**United Utilities Water Limited
Developer Services & Metering**

Your ref: 3/2018/0914
Our ref: DC/18/4460
Date: 08-NOV-18

Location : Land off Clitheroe Road Whalley (Lawsonsteads phase 2) BB7 9RG

Proposal : Erection of 188 new dwellings including means of access and associated works

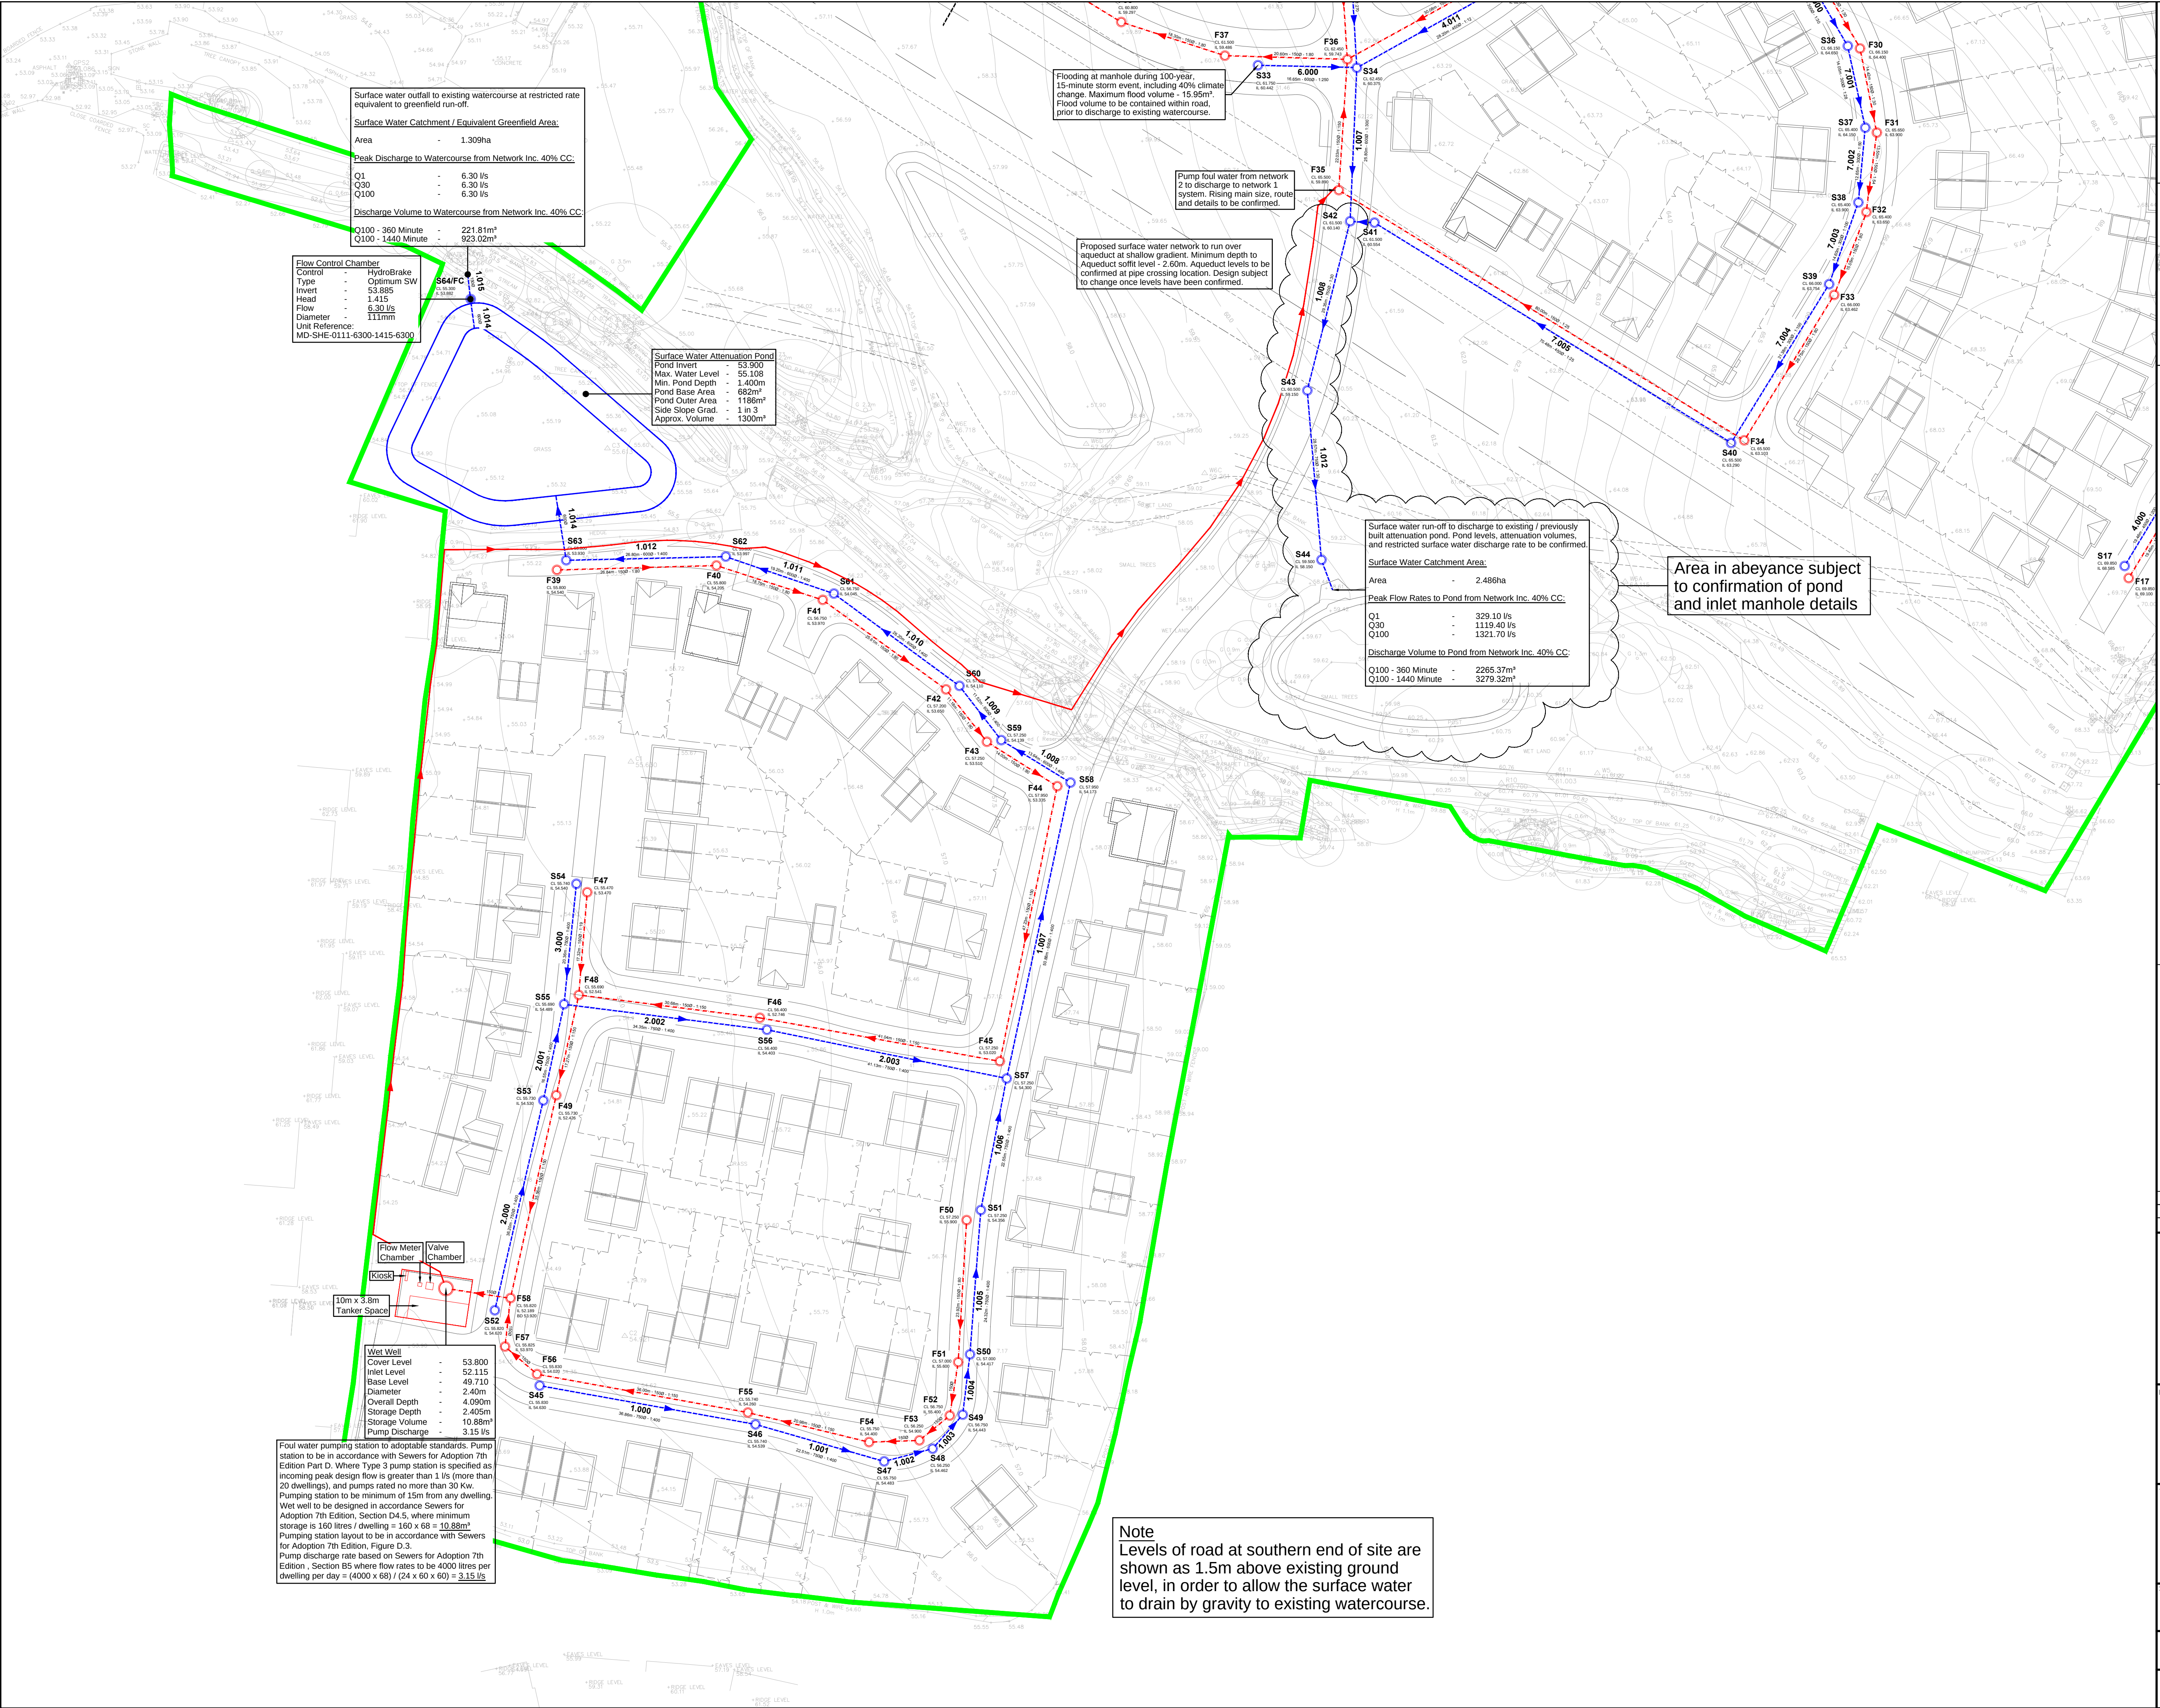
Further to our review of the 'Proposed Unit Mix Plan (Roof Plan) AA7403 2010 REV A, dated Sep 2018 and 'Below Ground Drainage Layout Sheet 2' Project Number 1040-01, Drawing Number D0102 Revision P2, it appears that the proposed ponds may be located in close proximity to the water pipelines and both foul and surface water drainage pipes constructed above the pipelines.

Whilst the principle strategy set out by the applicant is in line with United Utilities requirements, we suggest the applicant considers the location of the proposed rising main. We suggest the rising main should be located within the proposed carriageway rather than through residential rear gardens because this will have an effect on the future adoptability of the scheme.
